Your Ref: OWPC17505
Our Ref: M/123/17/HH 21-11-2017
Please ask for:
Mrs A Gardner

Two storey extension to existing building. Re-submission of M/71/17/HH
Little Thatch 93 Middleton Road Middleton on Sea

Thank you for your internet representation made on 4th March 2018 which has been recorded as '**an objection**' with the comments as follows:

EAST ELEVATION

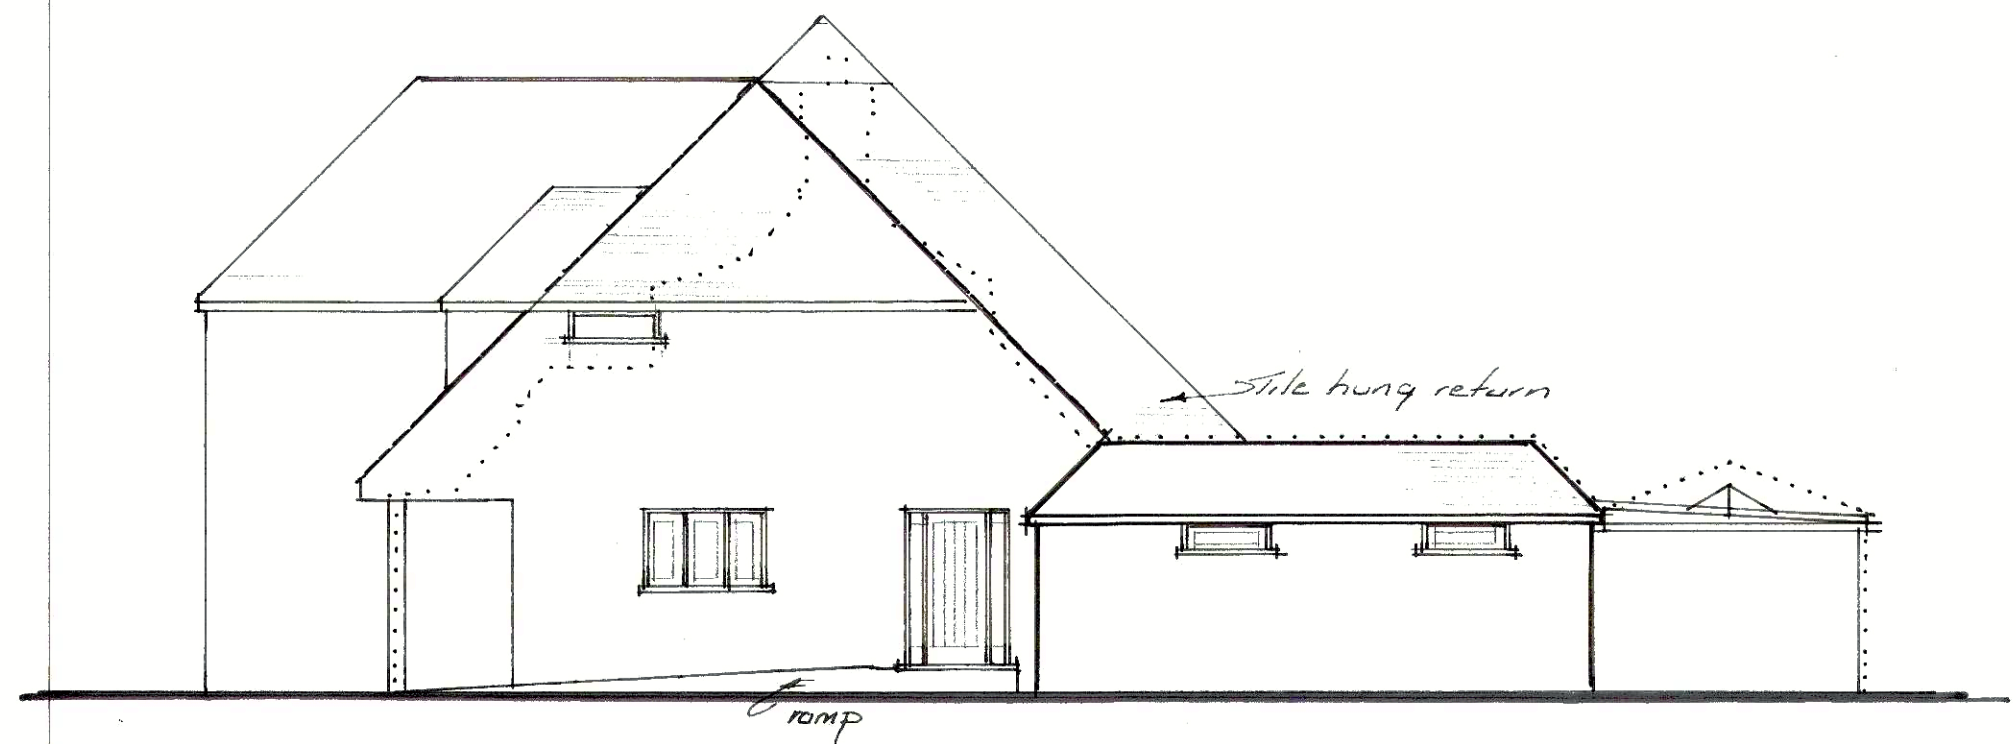
- the unusual set back of no. 93 (which results in the building running along the length of our rear garden)*
- its position so close to the eastern boundary*
- the substantial size and independent nature of the annexe and*
- the existing low eaves along with the lack of any first floor window or ground floor door on the east elevation.*

Without prejudice to our objections above, should the Application be approved we would like to repeat our earlier request for a number of conditions to be imposed. In addition, no glazing should be added in the future to the eastern elevation (wall or roofslope) of the front projection. Nor should any additional doors be added to the annexe (including the conversion of the study and utility windows).
